Application number(s):	23/03277/F
Application site:	Stable Lodge Middleton Stoney House Oxford Road Middleton Stoney Bicester OX25 4TE
Proposal:	New detached two storey house with detached garage - Re-submission of 23/01365/F

Conservation Officer: Emma Harrison

Date: 11/01/2024

Drawing Title:
 PROPOSED GROUND FLOOR PLAN

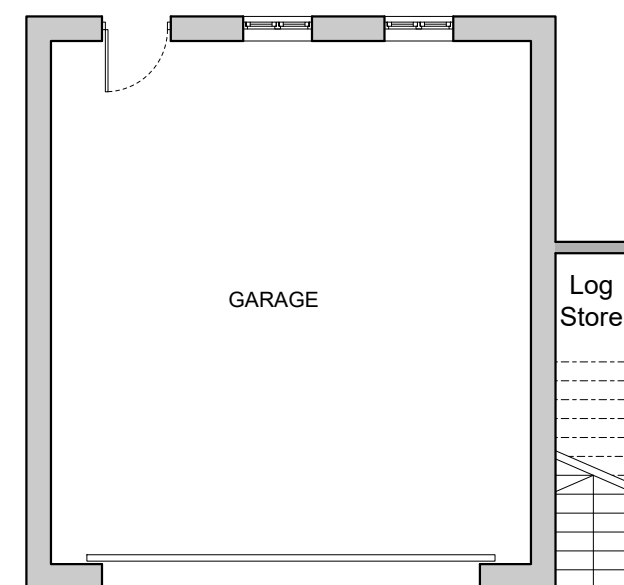
The design and massing of the proposed dwelling is considered to be out of keeping with the properties within the village and also to dominate and detract from the Listed Building, therefore rendering it to be considered to be inappropriate in this location. This is a sensitive site, and it is considered that any development here would be difficult to achieve, but something more akin to a modest cottage within the grounds or converted outbuildings may be more acceptable and have less of an impact.
